Our Ref: EN010163

Application by Steeple Solar Farm Limited (“the Applicant”) for an Order granting Development Consent for the proposed Steeple Renewables Project (“the Proposed Development”)

REQUEST FOR INFORMATION

Figure 7.13.1: Skylark mitigation in the Western Biodiversity Mitigation Area

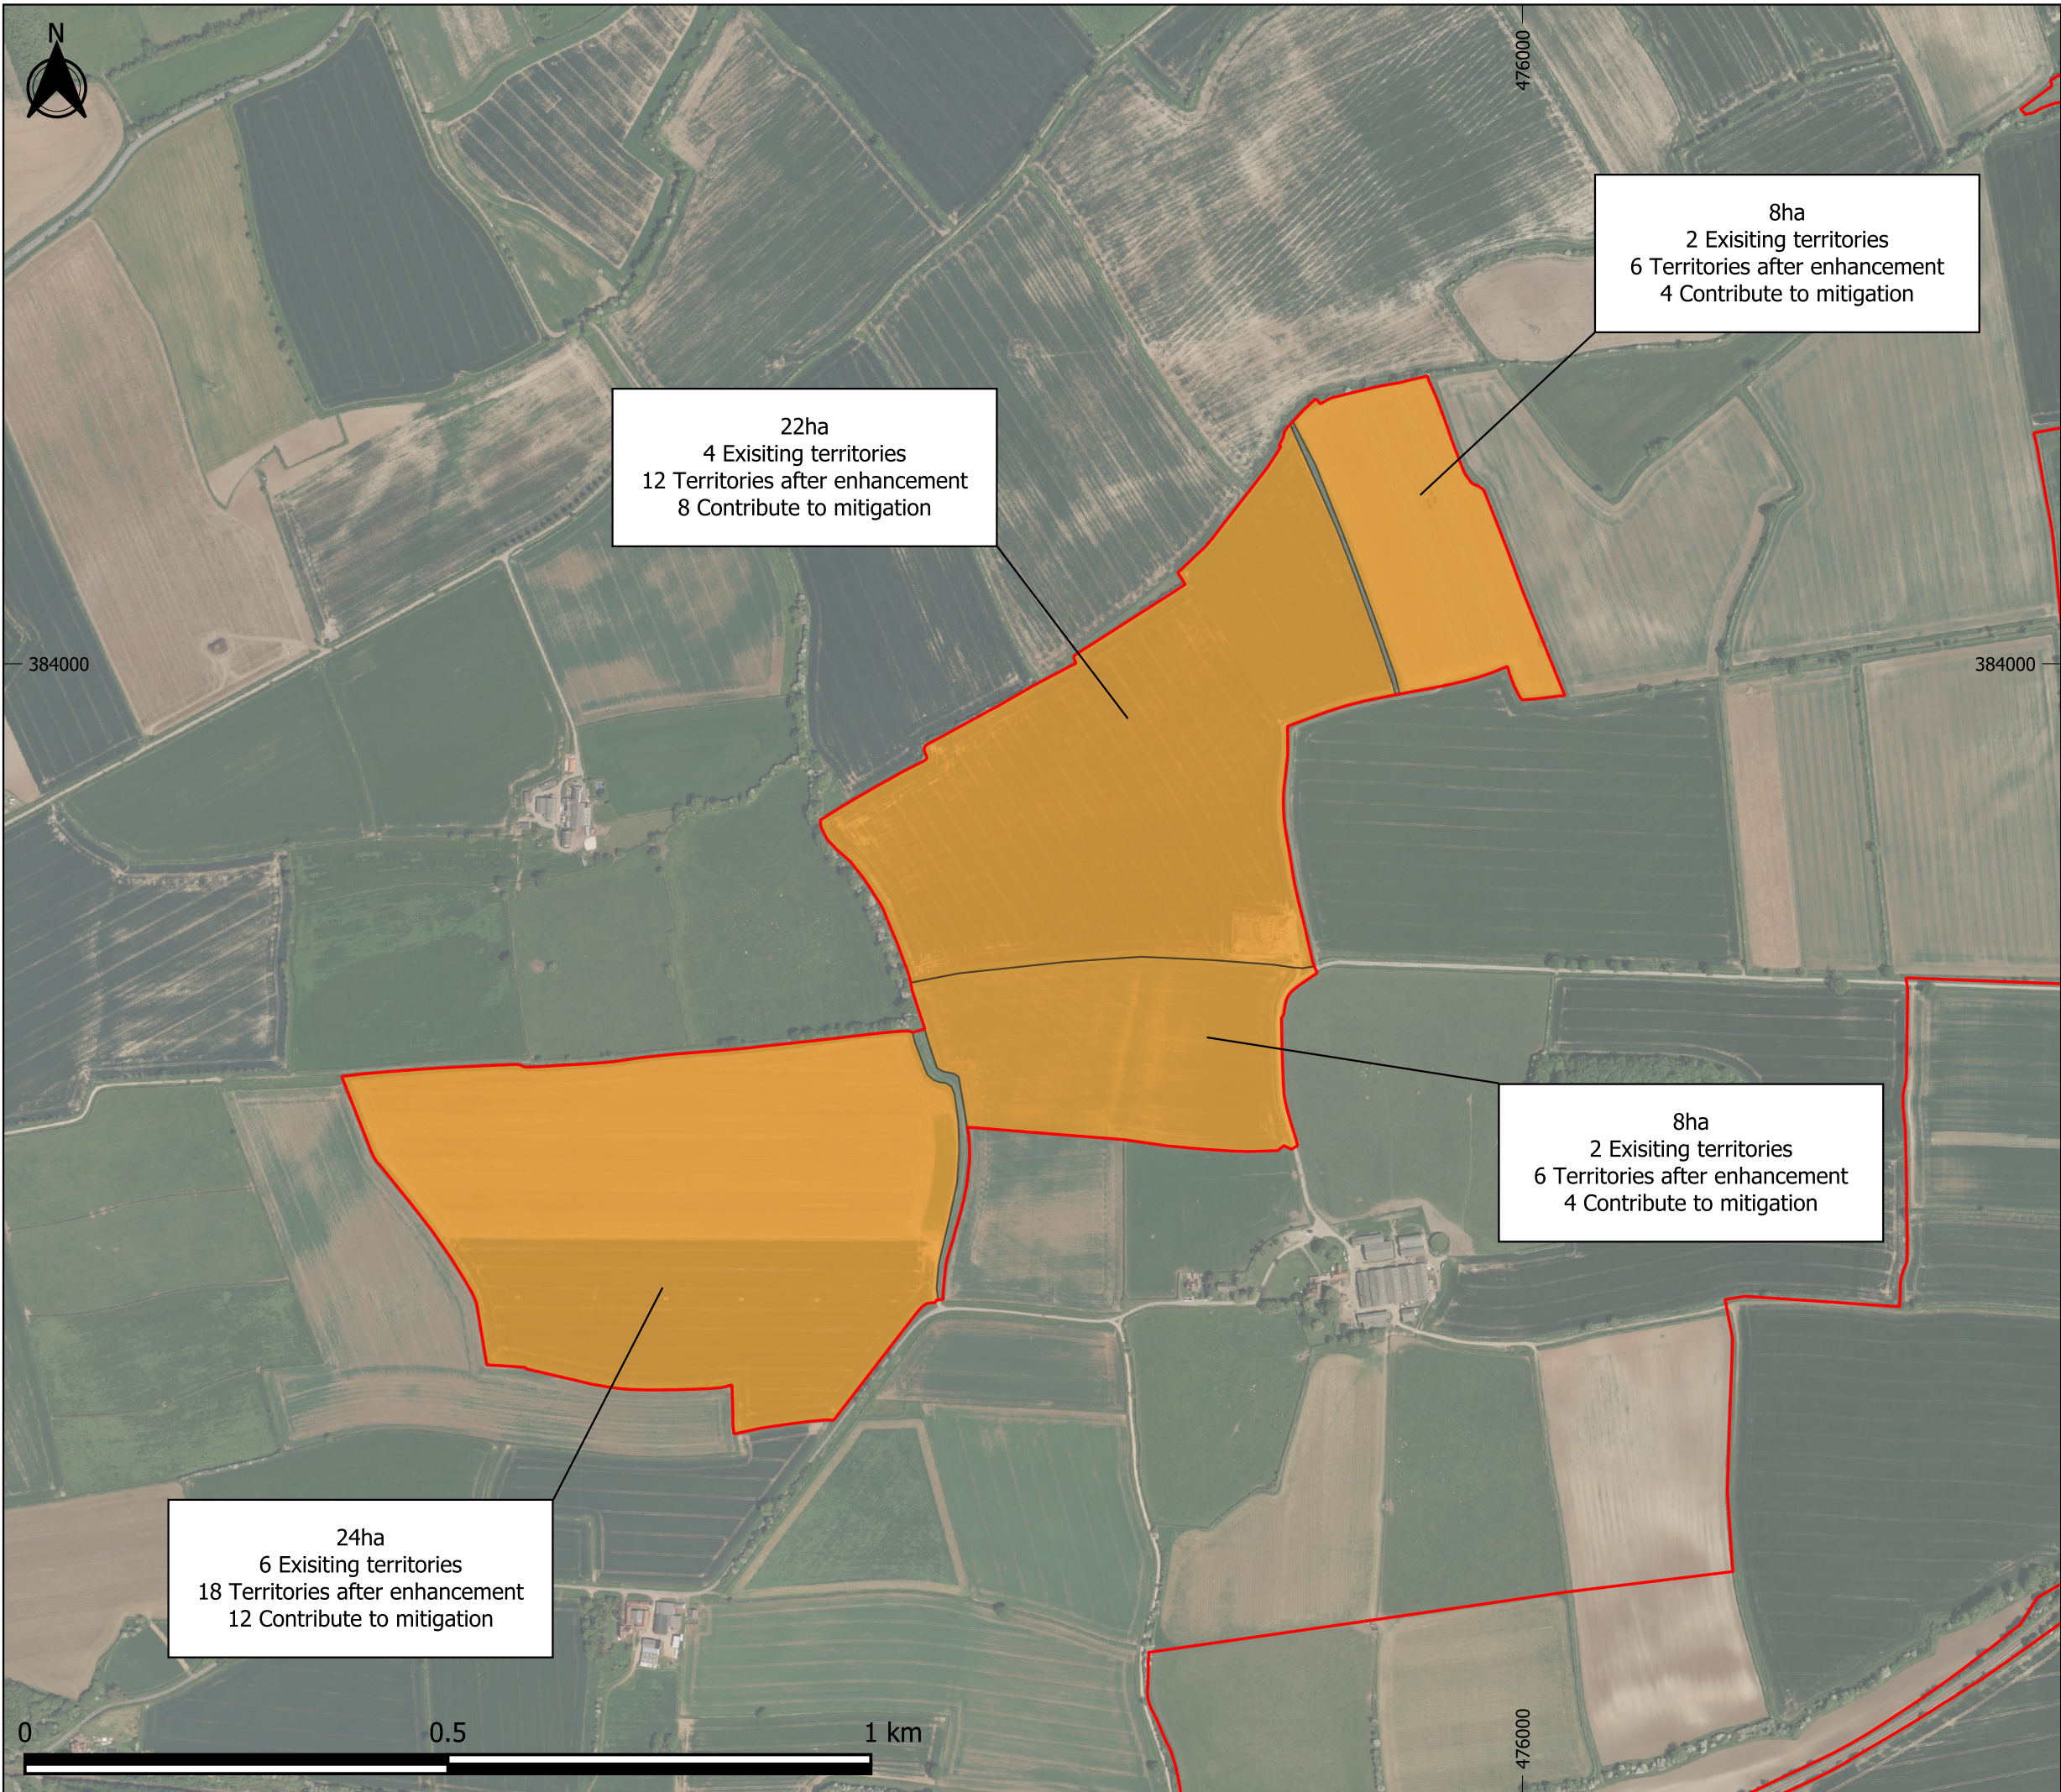
3. The Secretary of State notes the Wildlife Trust’s comments regarding the potential to improve the mitigation outlined for loss of breeding skylark territories [RR-055]. The Skylark Mitigation Strategy [APP-115] states that the Eastern and Western mitigation areas will use arable management in conjunction with skylark plots to mitigate impacts to breeding skylark. The Biodiversity Net Gain assessment [APP-114] indicates that significant proportions of the mitigation areas will be converted from ‘winter stubbles’ to ‘cereal crops’. The Secretary of State requests that **the Applicant** update the Skylark Mitigation Strategy to manage the parts of the mitigation areas to be targeted for breeding skylark using a spring cropping regime, to provide increased suitability for breeding and foraging skylark year-round. Should this approach not be feasible, **the Applicant** should justify their position

within the Skylark Mitigation Strategy, detailing the merits of their proposed strategy in relation to a spring cropping regime.

4. The Secretary of State notes the approved plans for Wood Lane Solar (20/00117/FUL) adjacent to the Western mitigation area. **The Applicant** is requested to update the Skylark Mitigation Strategy to account for any boundary or in combination impacts would could arise via the proximity of this development.
